King Forest

Review of Revised (2017) Koala Plan of Management

Department of Planning and Environment

September 2017

TITLE
PRE-CONSTRUCTION
KOALA
MANAGEMENT ACTIONS
- PRECINCTS 12-14

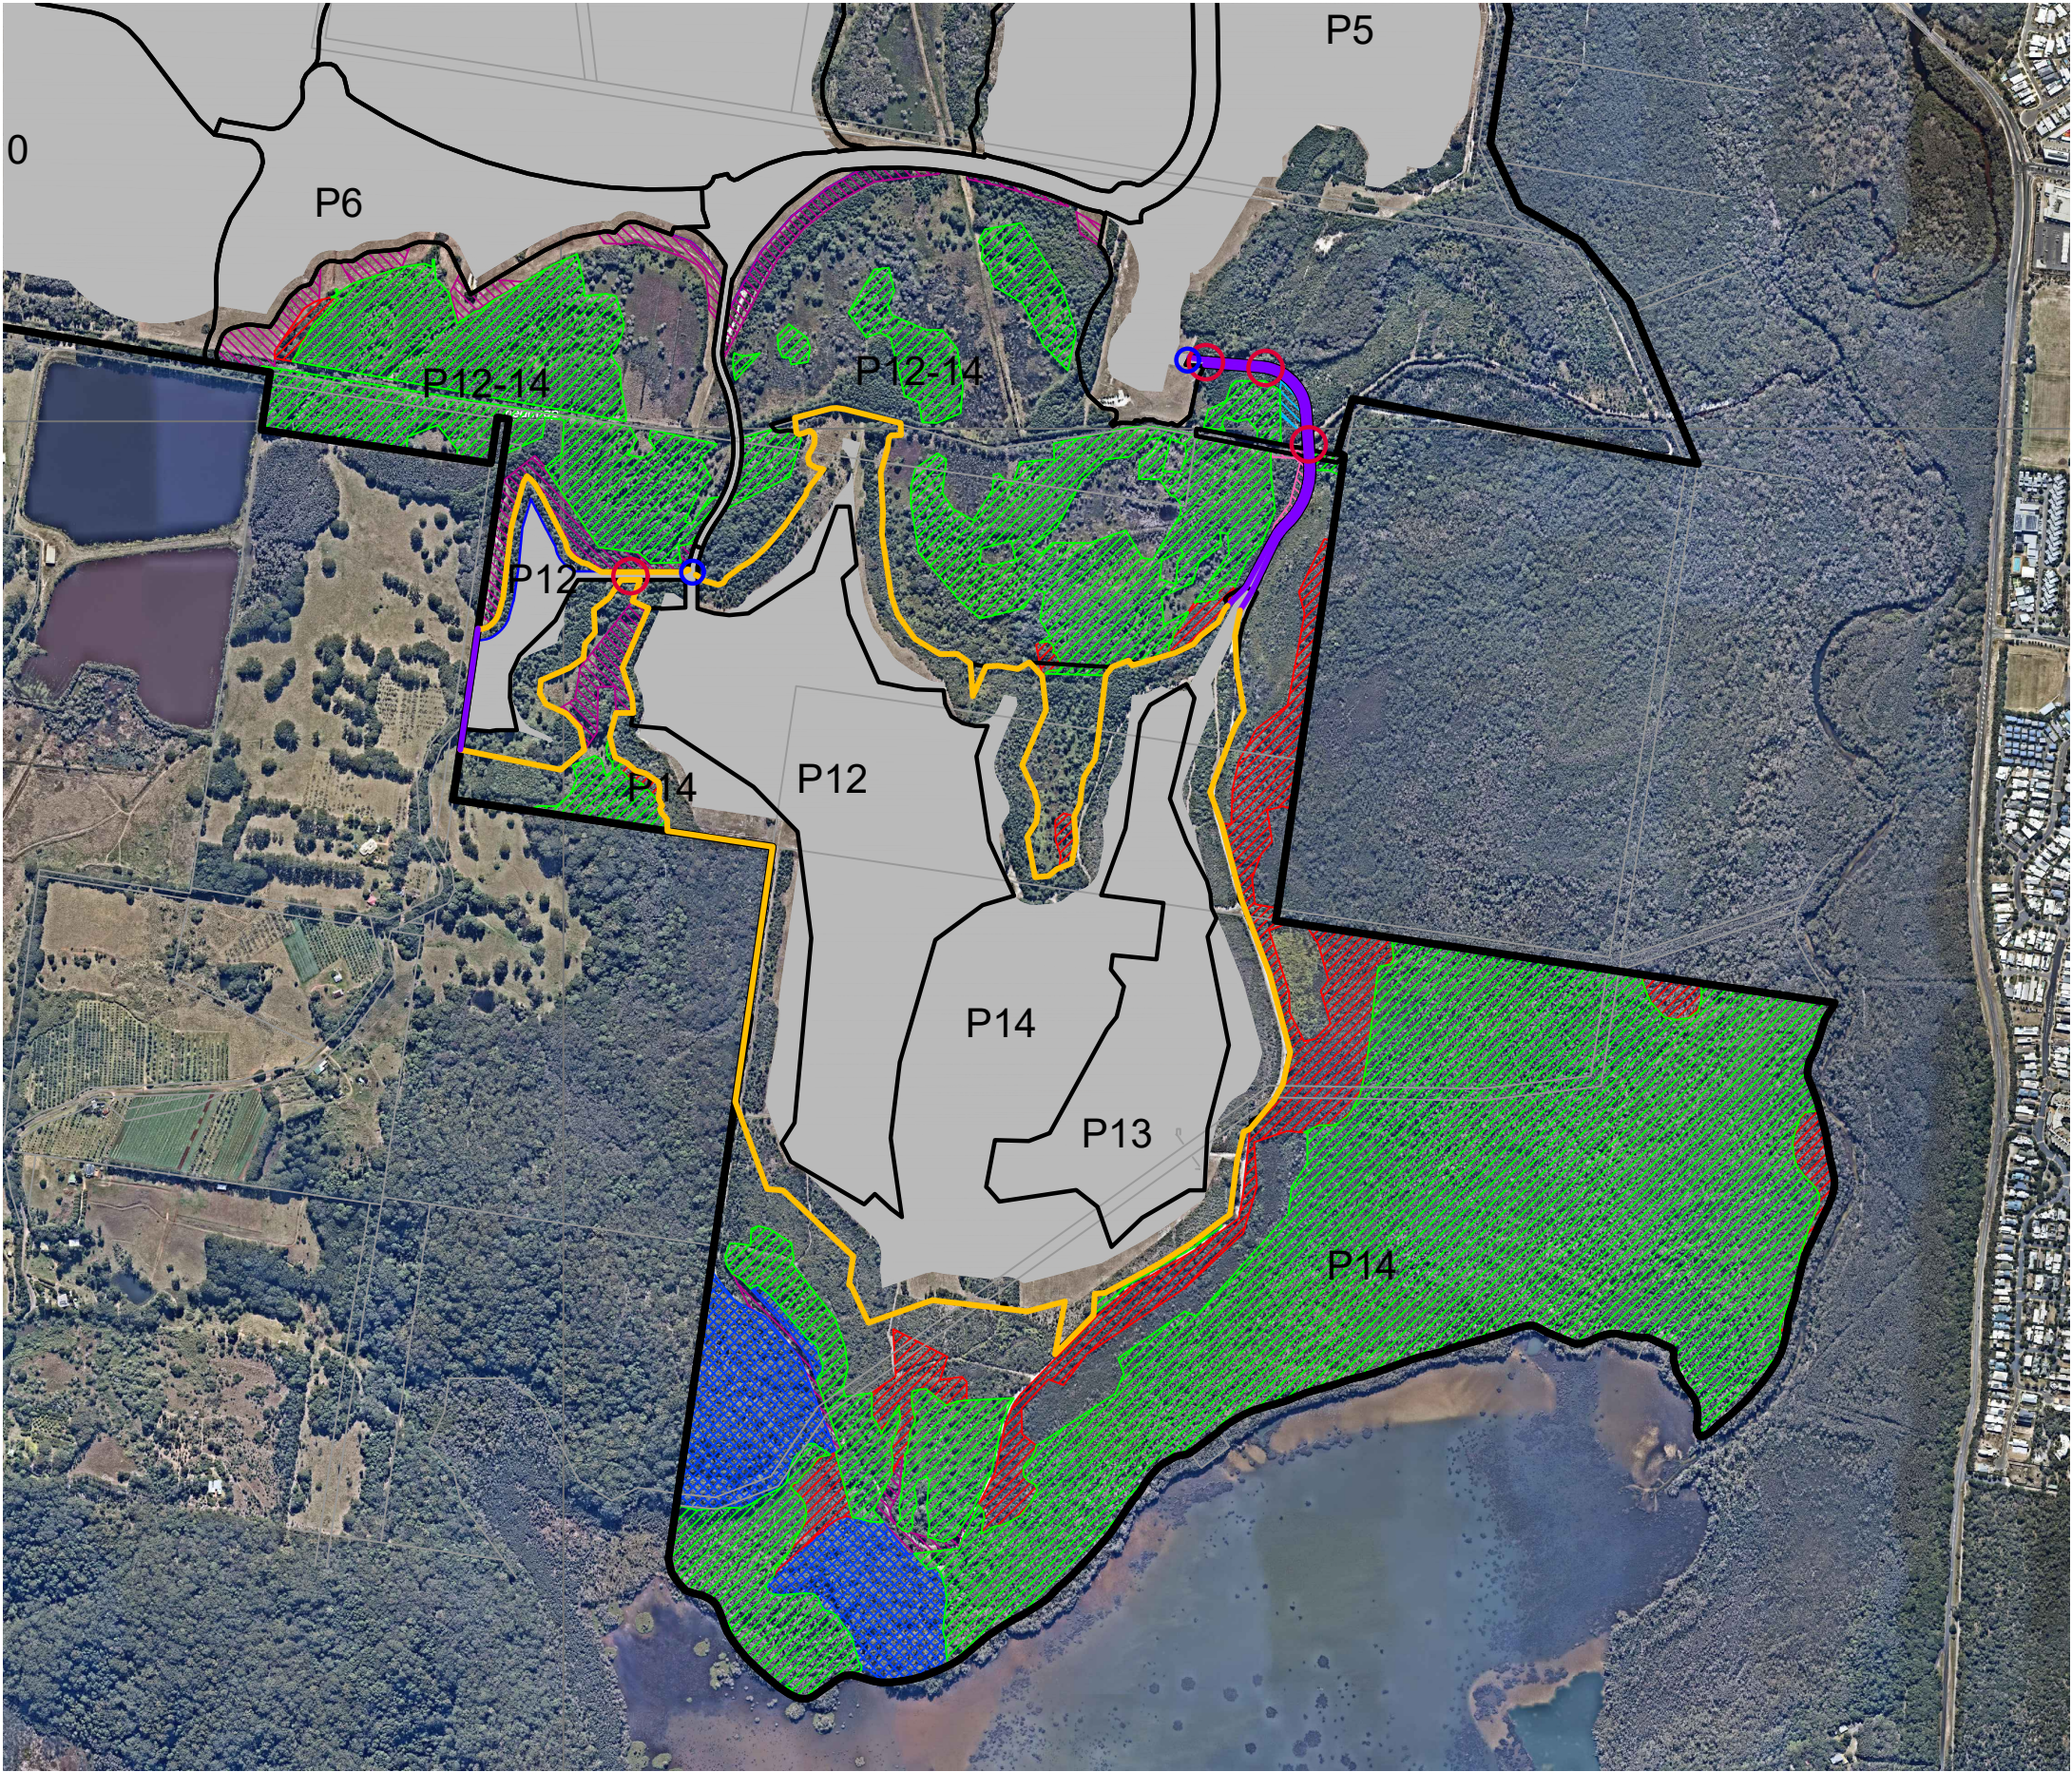
14. For the golf course (precinct 14), permanent fencing is shown to both the north and south of the golf course, which would prevent koala movements through this area, which was identified in both the original and Stage 1 KPoM's as a koala movement corridor. Fencing is proposed to be inspected twice a year, with any damage repaired within 2 days of discovery. An area of 'Primary Koala habitat to remain after development' for Precinct 14 is shown as being located on the 'development' side of the proposed permanent fence.	3. Crossing point locations. It is difficult to understand where structures are proposed to be located to facilitate koala movements across the site as a whole. However, Figure 37 (for precincts 12 - 14) has been reviewed. This precinct has multiple roads through koala habitat or other conservation areas. A total of one grid appears to be proposed in the north-eastern portion of this precinct. It is unclear how this one grid would allow koala movements to proceed, and for koalas to avoid vehicular strikes and fatalities. The KPoM appears to be substantially deficient in

b. The installation of permanent and/or temporary fencing along both sides of access roads for precincts 6, 7, 11, and 12-14 to be reviewed. Fencing both sides of the access road may be supported where adequate koala crossing culverts are installed. However, if none are installed, then access roads must incorporate 'traffic calming' adequate to slows vehicles to a maximum speed of 60km/hr for the entire length where the road passes through conservation areas. For clarity, koala crossing culverts are the option with a significant preference by the reviewers,
		 Location of fencing for precinct 14 to be amended so that primary koala habitat proposed to be retained, is not on the 'development' side.
